MODIFICATION REQUEST:

***Lot 2 DP 748682
132-138 Killeaton Street, St Ives***

***MP10_0057 MOD 5 – Modification to
Approved Monastery Building***

Director-General's
Environmental Assessment Report
Section 75W of the
Environmental Planning and Assessment Act 1979

DRAWING TITLE:
MONASTERY - ELEVATIONS & SECTION

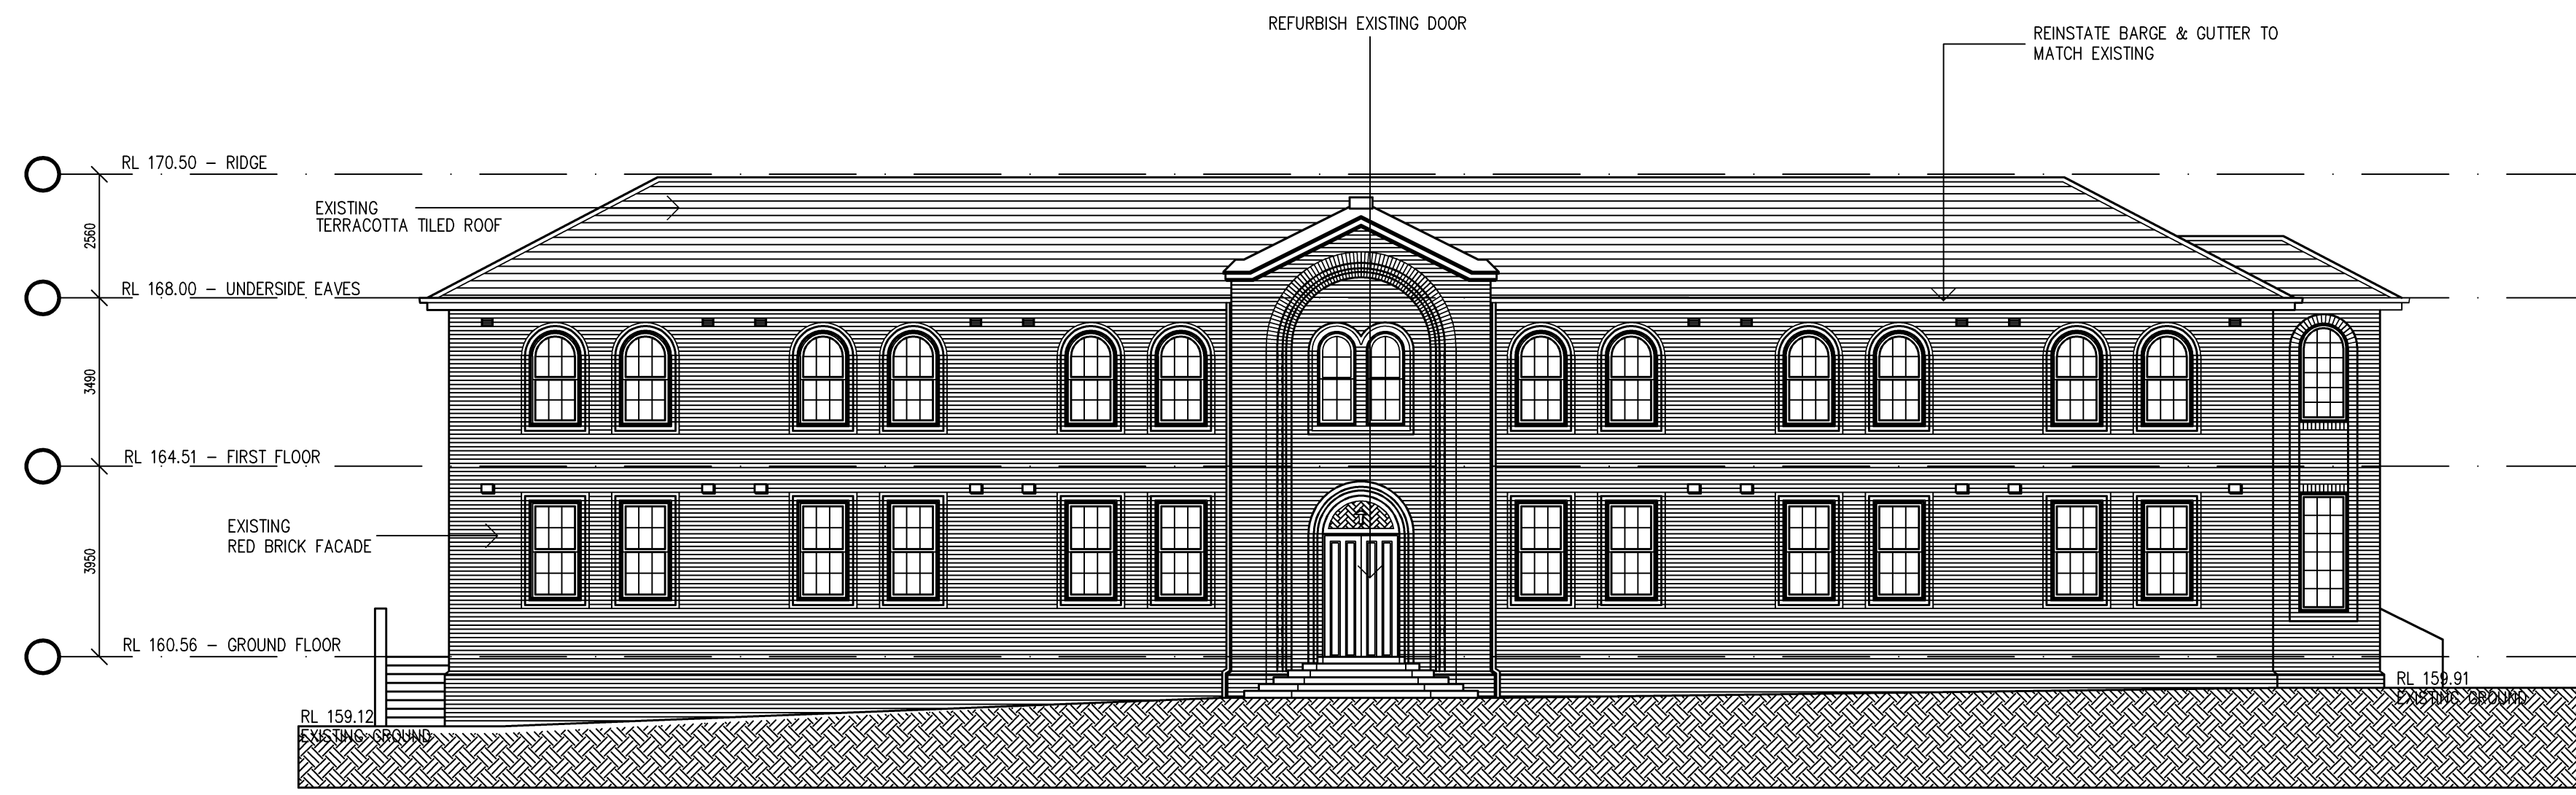
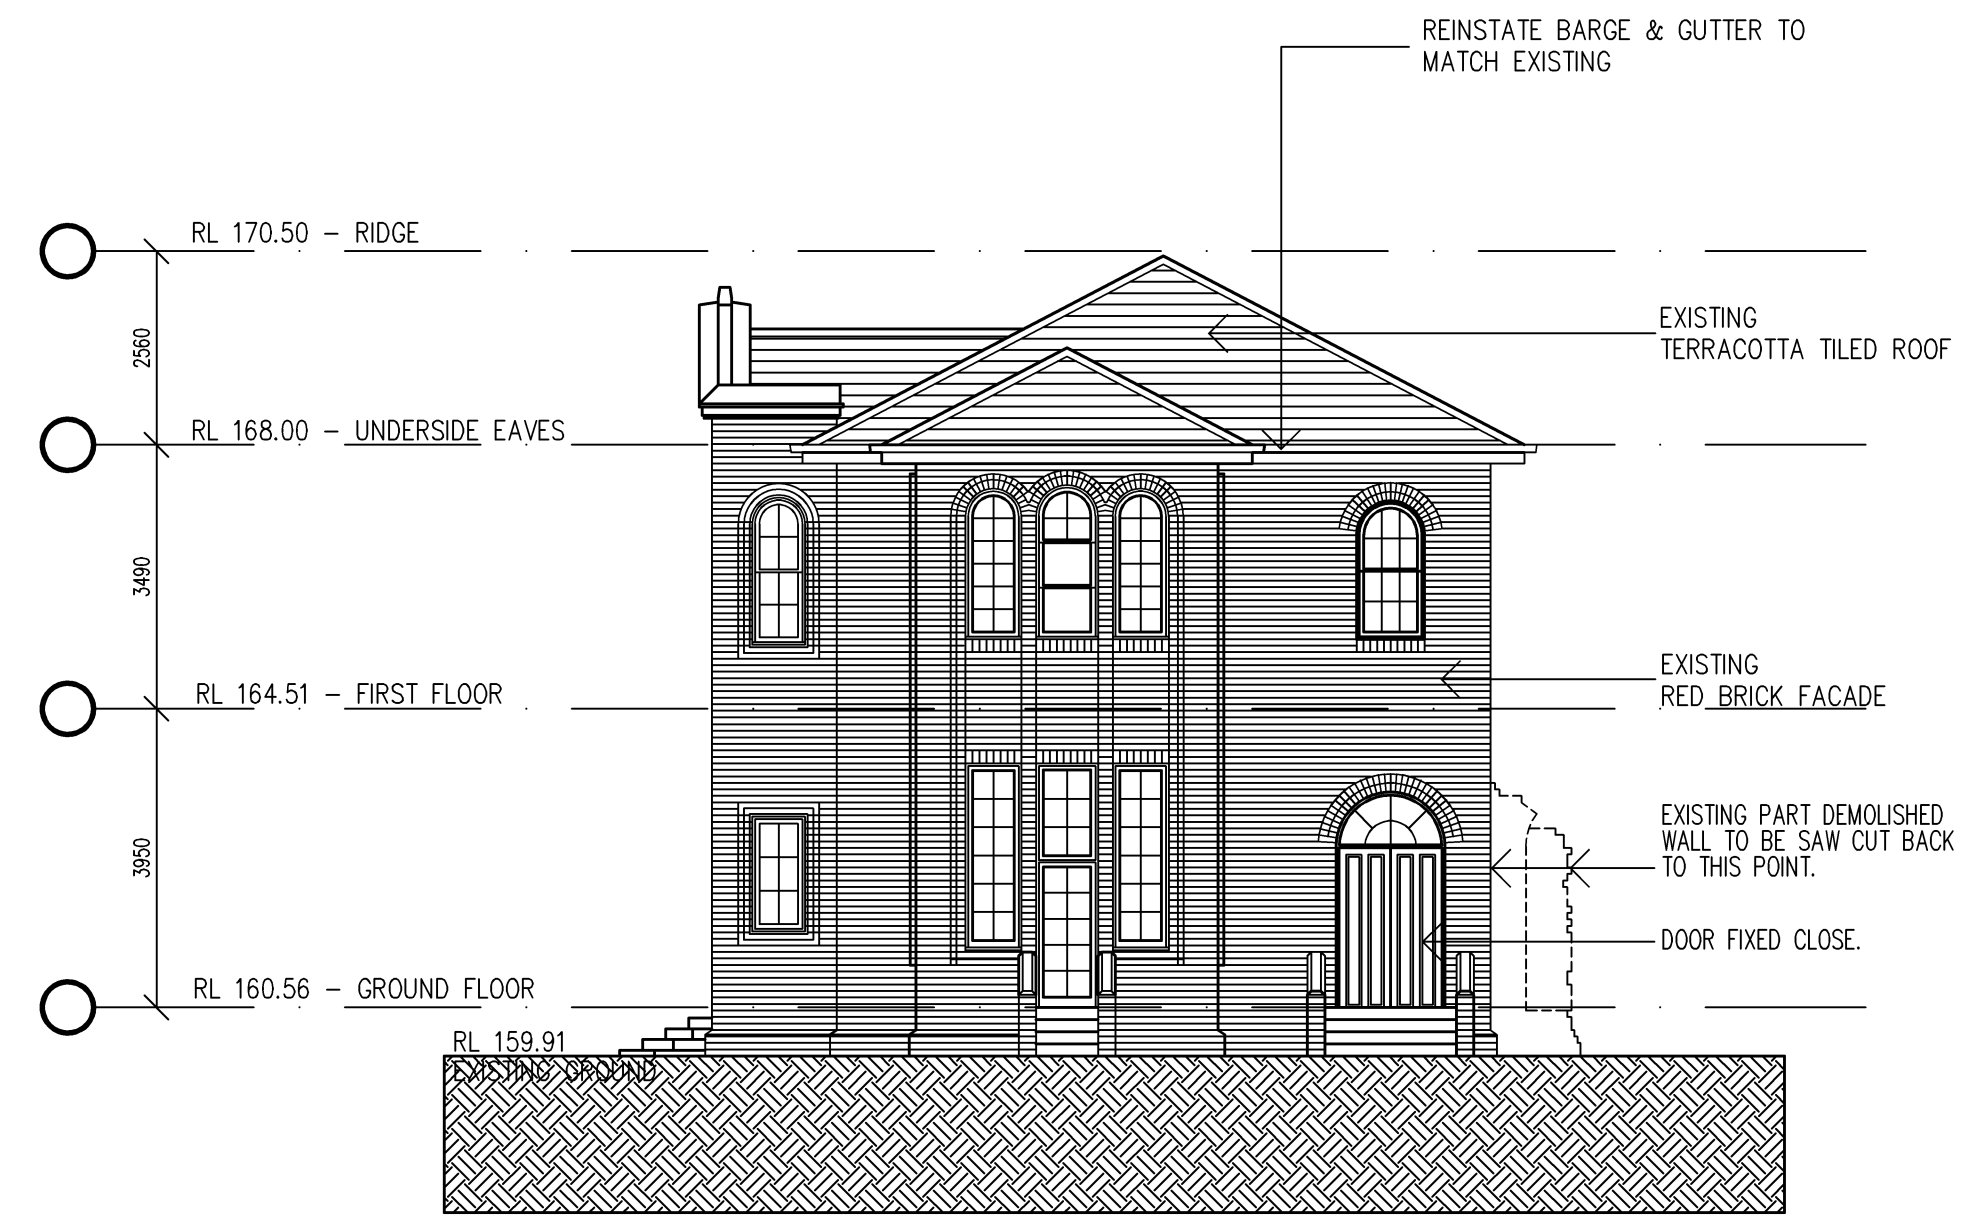
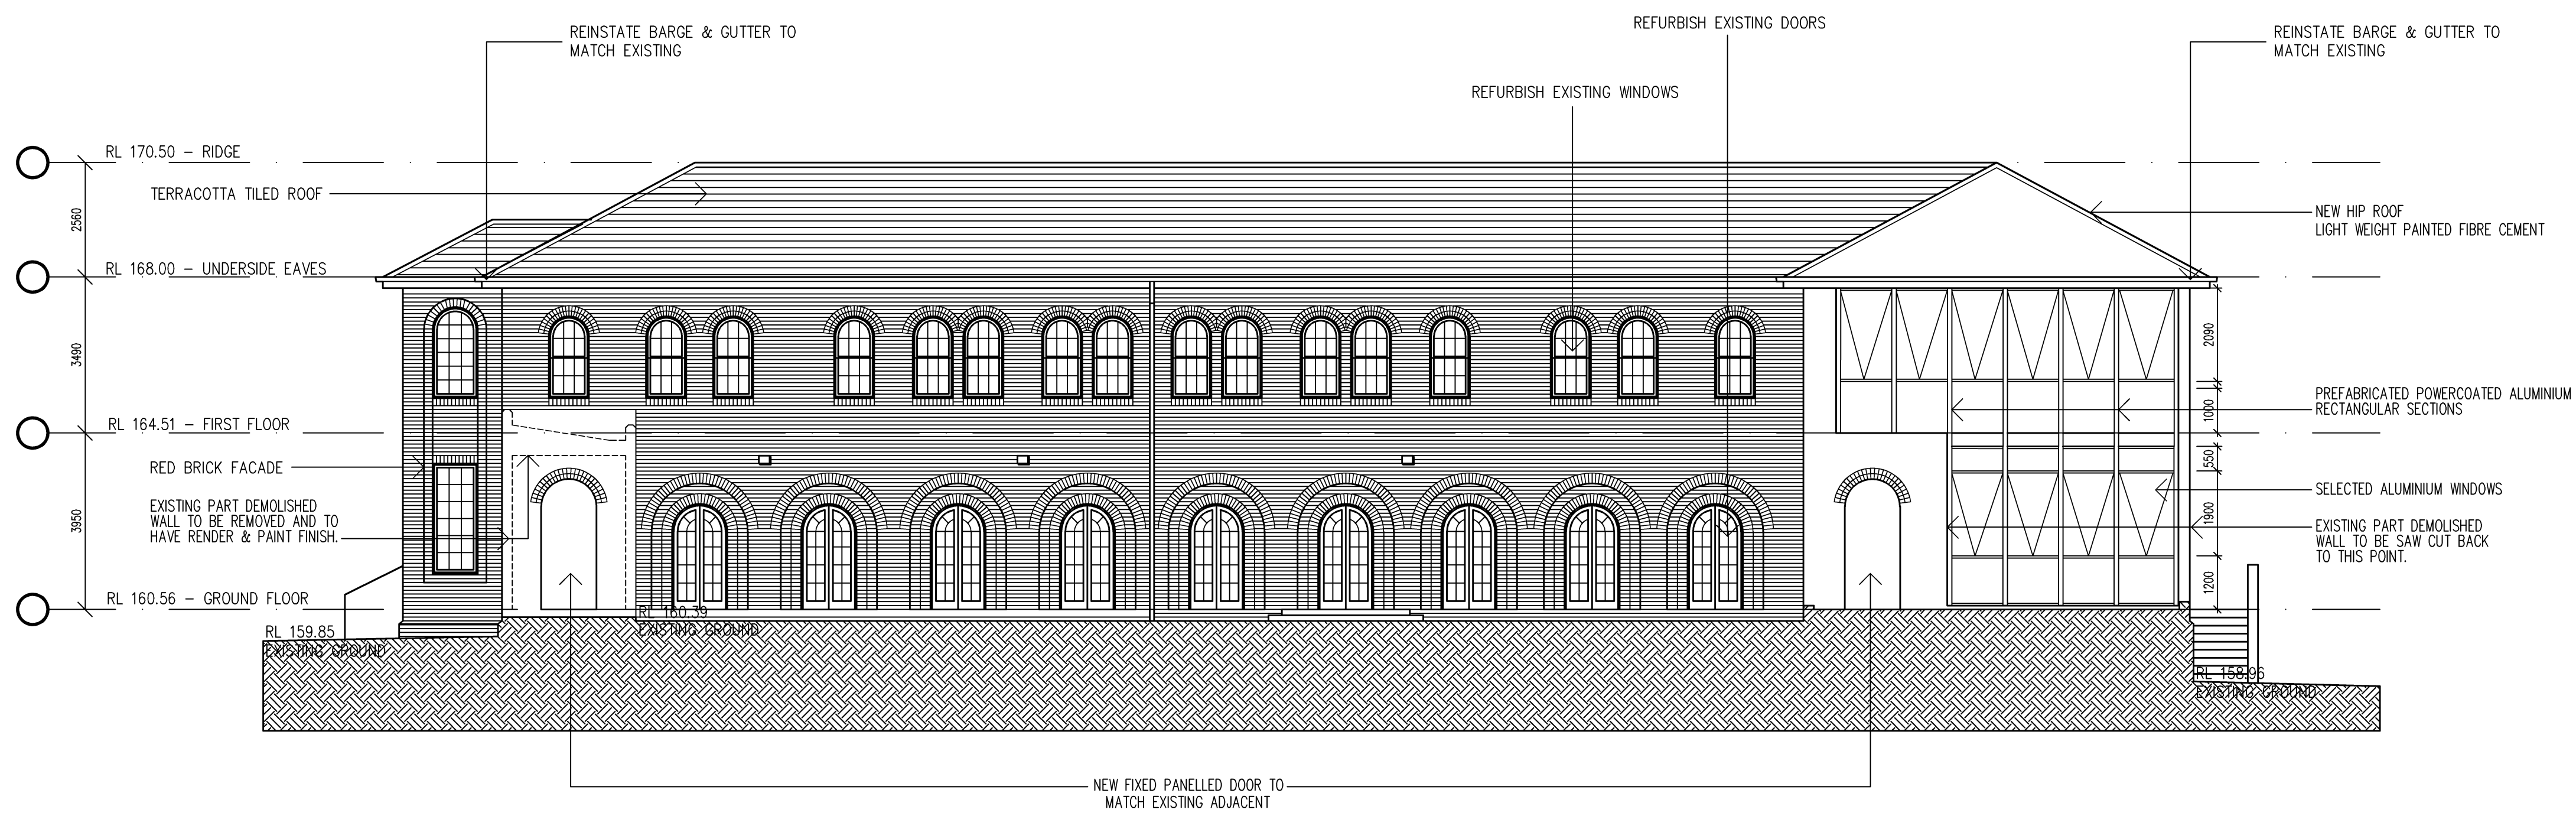
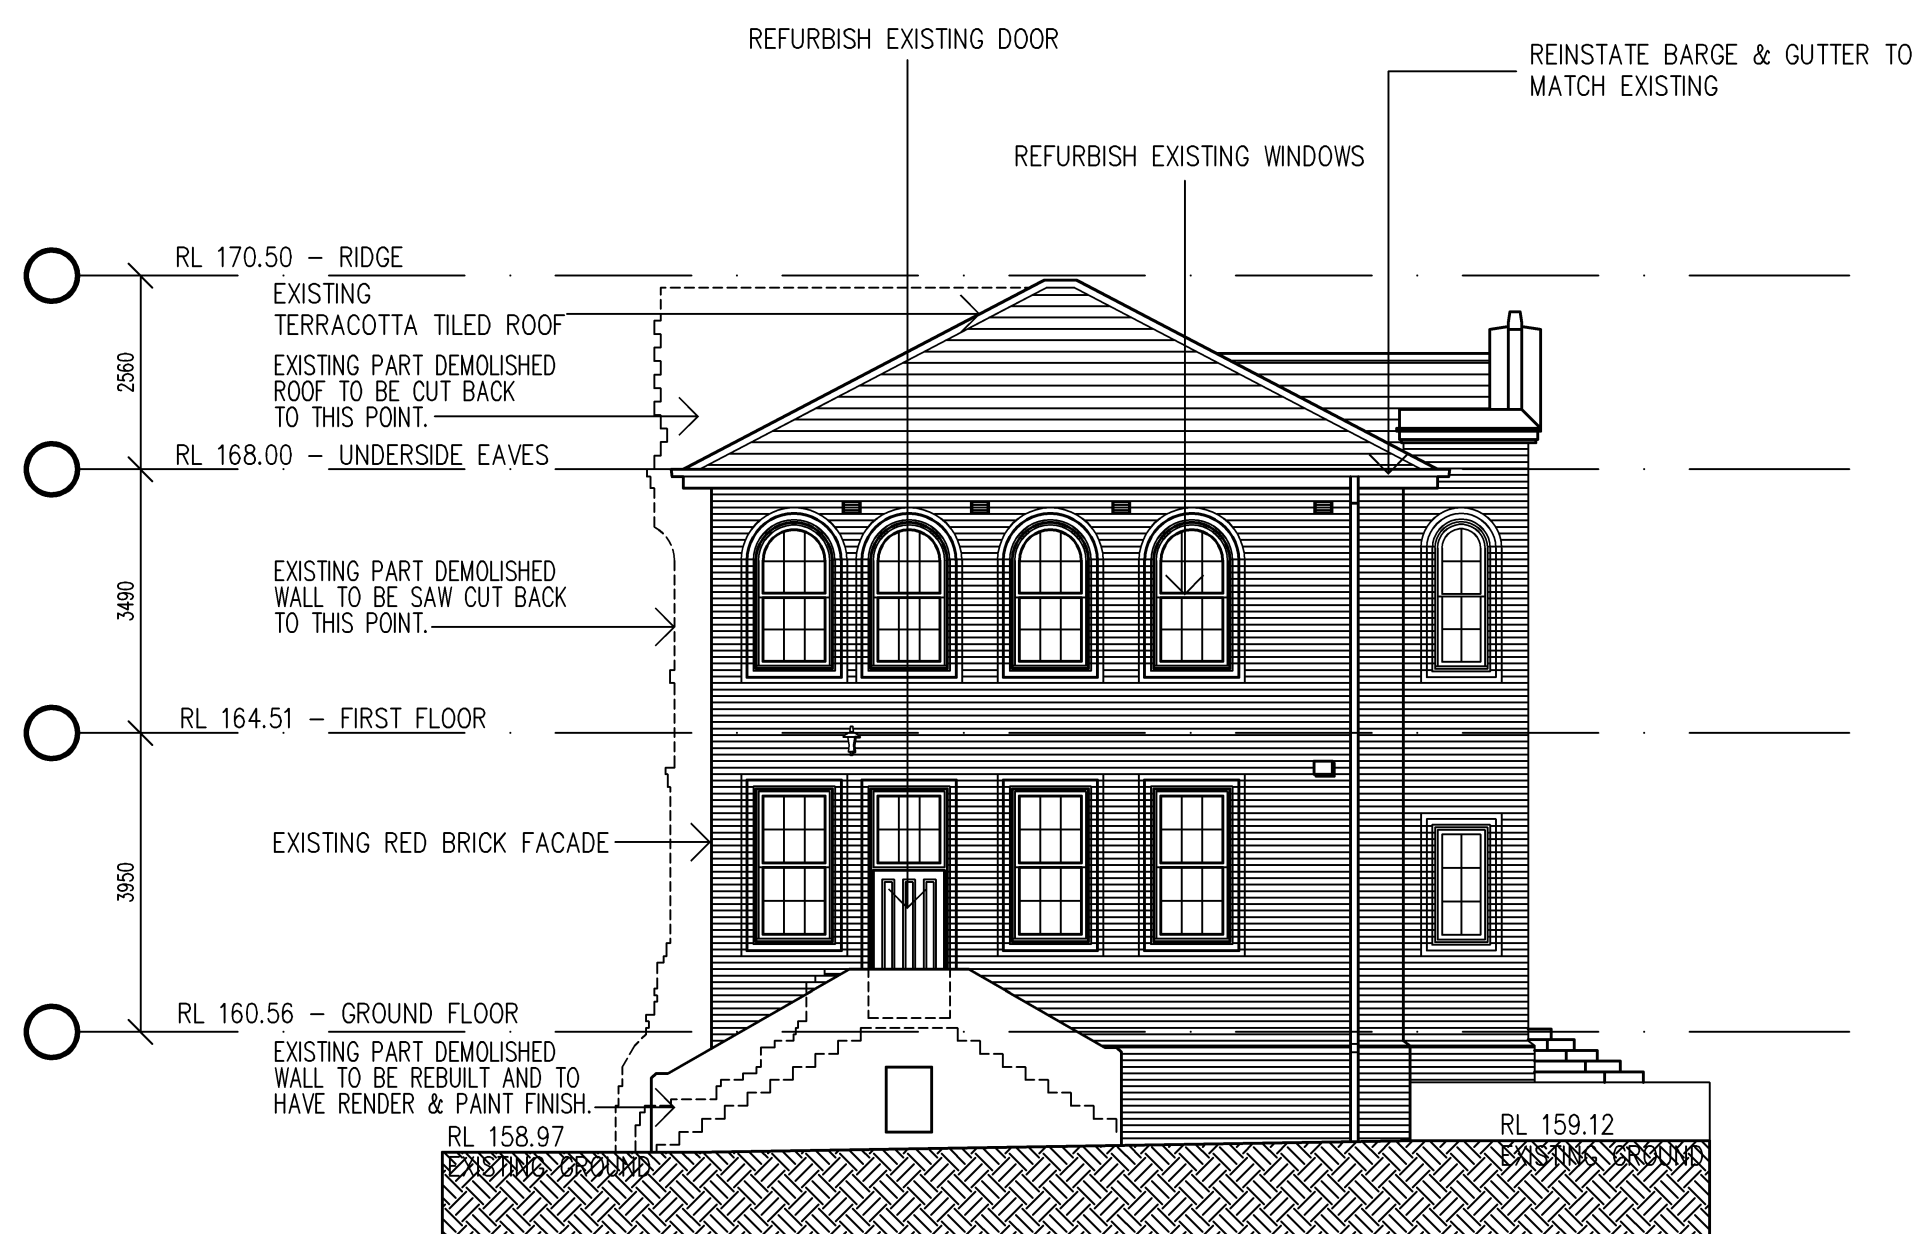
In response to concerns raised by Ku-ring-gai Council, the proponent has offered to provide obscure glazing to the lower half of the west-facing windows of the balcony of the four bedroom unit. The department considers this measure to be sufficient in reducing the potential impact of overlooking the adjacent Block F and protecting the privacy and amenity of the unit within the Monastery building. This is reflected in Condition C3 'External Materials and Finishes (existing monastery building)' of the attached Recommended Modifying Instrument.

The Council also raised concern that the existing balcony on the western side of the building is undersized and does not provide sufficient residential amenity for this four bedroom unit (**Figure 5**). The dimensions of the existing balcony are 4.05 metres (width) x 2.06 metres (depth) with an area of 8.343m². The department considers the adaptive re-use of the existing balcony to be an appropriate method of private open space for this unit as it satisfies the intent of the Residential Flat Design Code with respect to balconies as the design maintains the external appearance of the building and it provides usable private open space accessible from the main living areas. The proposed units also have access to the community facilities on the ground floor and the common open space area that adjoins the Monastery building. These measures are considered to complement the private open space provided by the balcony areas of the proposed units and are supported by the department.

The proposed modifications result in minimal alteration to the external appearance of the existing Monastery building as previously approved. It is noted that the site is not listed as an item of environmental heritage in the *Ku-ring-gai Planning Scheme Ordinance*, and there are no other heritage listings associated with the site. Part of the southern elevation features full-length windows which differ to the design of the remainder of the building, however it is noted that this design was approved in the Project Approval (MP10_0057) and is proposed to be retained (**Figure 8**). This portion of the external façade was previously demolished in conjunction with a wing of the original building. As discussed in Section 5.1.2 above, the proponent has offered to provide obscure glazing to the lower half of the existing balcony windows on the first floor of the western elevation to prevent overlooking the adjacent residential unit (**Figure 9**).
